Application No: FP/179/20/PL
Site Address: 7 Ambleside Close Felpham PO22 8NG
Description of works: 1 No 3 bedroom detached chalet bungalow. This site is in CIL Zone 4 and is CIL Liable as new dwelling.

Thank you for your internet representation made on 30th September 2020 which has been recorded as an objection with the comments as follows:

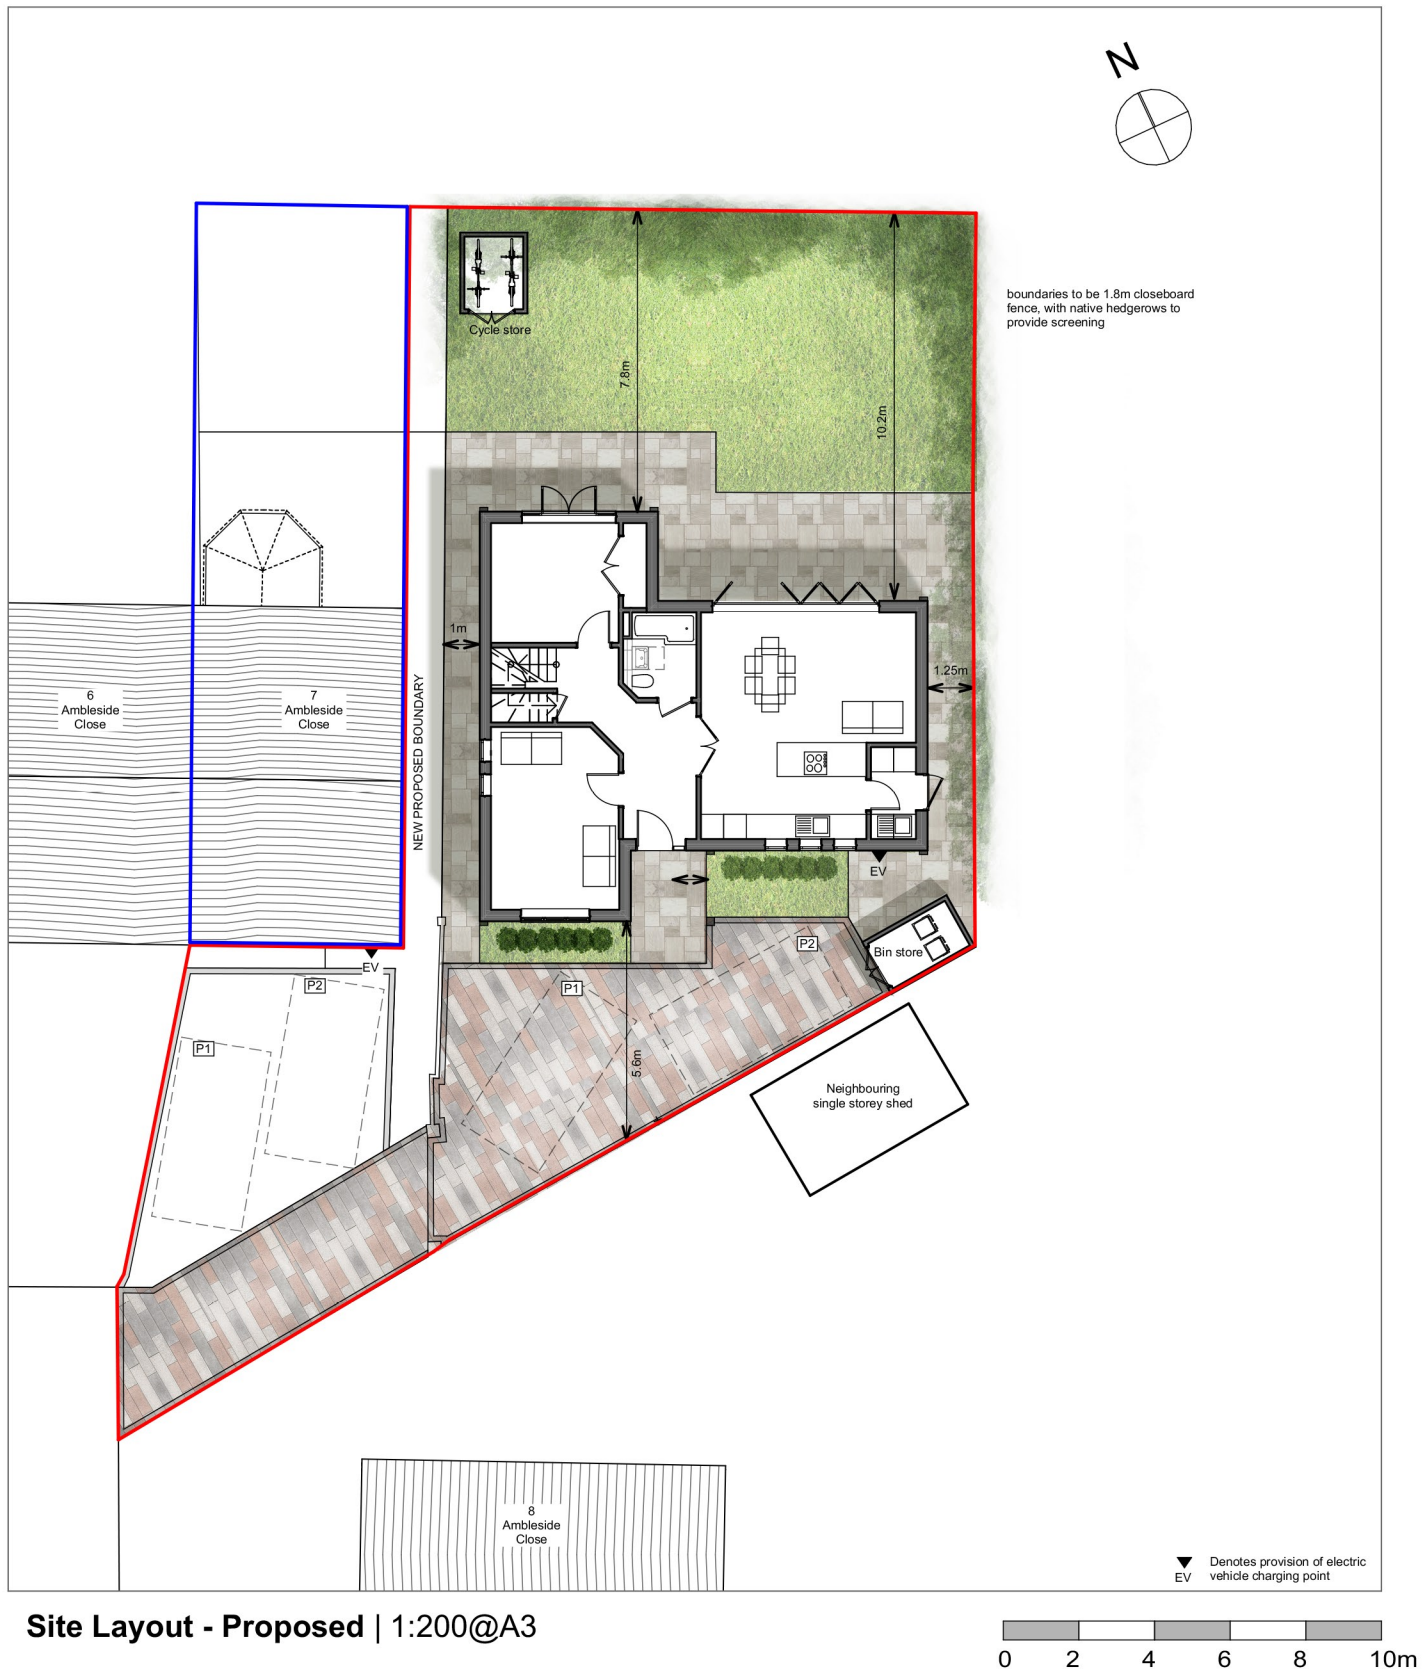
Although the proposed driveway surface is permeable, the cul-de-sac floods extensively during periods of heavy rain, and in some extreme events, rain water has made its way most of the way up to the driveway of several properties, and I am therefore concerned about the effect of the enhanced water runoff created by the patio area and large roofing area of the development.

In addition to this, parking within the cul-de-sac is already limited and has caused contention between neighbours in the recent past. Whilst it has been proposed to create two parking spaces, there is concern that the driveway proposed would not be properly utilised due to its narrow entry and sharp turning arcs. The possibility of a three bedroom house proposed means that there is the potential for up to three couples to move into the property - in theory up to an additional six cars.
